Re: BP#2017-00012 - 23 Ocean Avenue - Further plan review comments

- 23 Ocean Code Analysis
 - I have updated the analysis to more clearly describe the parking. It was initially included in the comments column. It has now been included in the main body of the table. The basement storage has also been added. A column has been added with an asterix to indicate which lines have been edited.

**L-2.0**

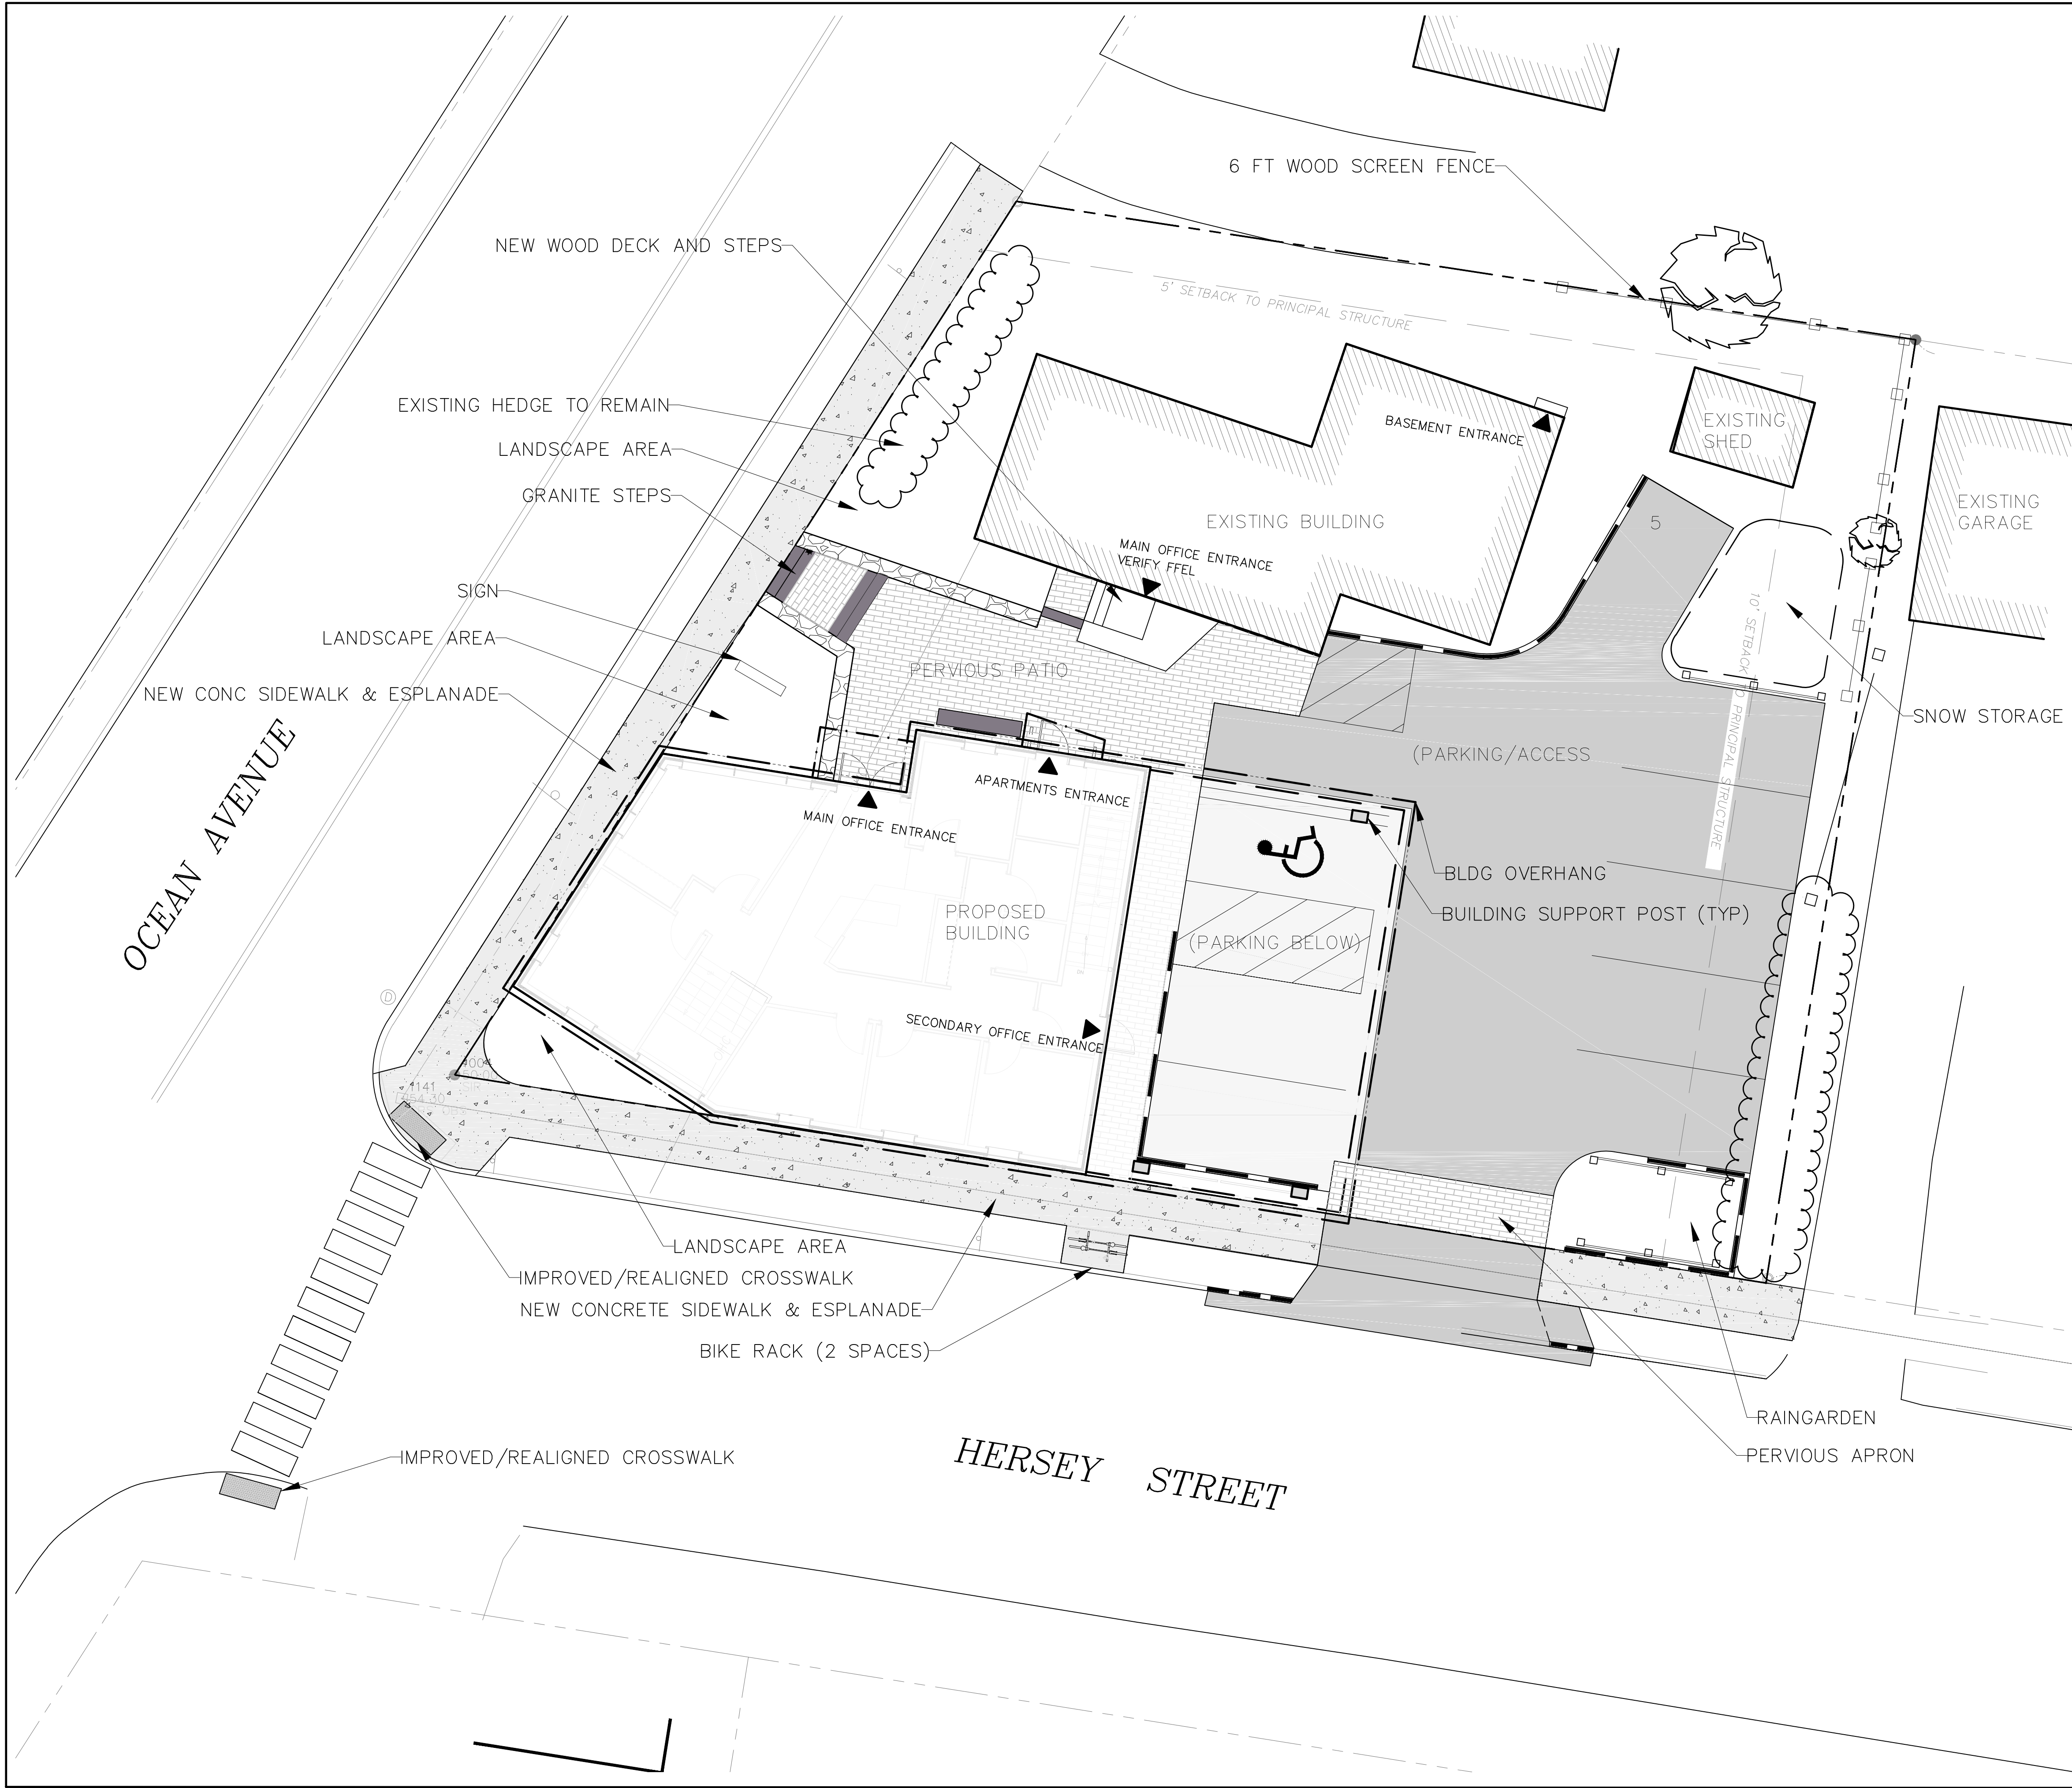
- L2.0 Site Plan
 - This has been updated by Carroll Associates to describe the separation distances. I have included a pdf of table 602 marked up to indicate how our building relates. This is also called out on page two the Code Analysis, but the actual table may make it clearer.
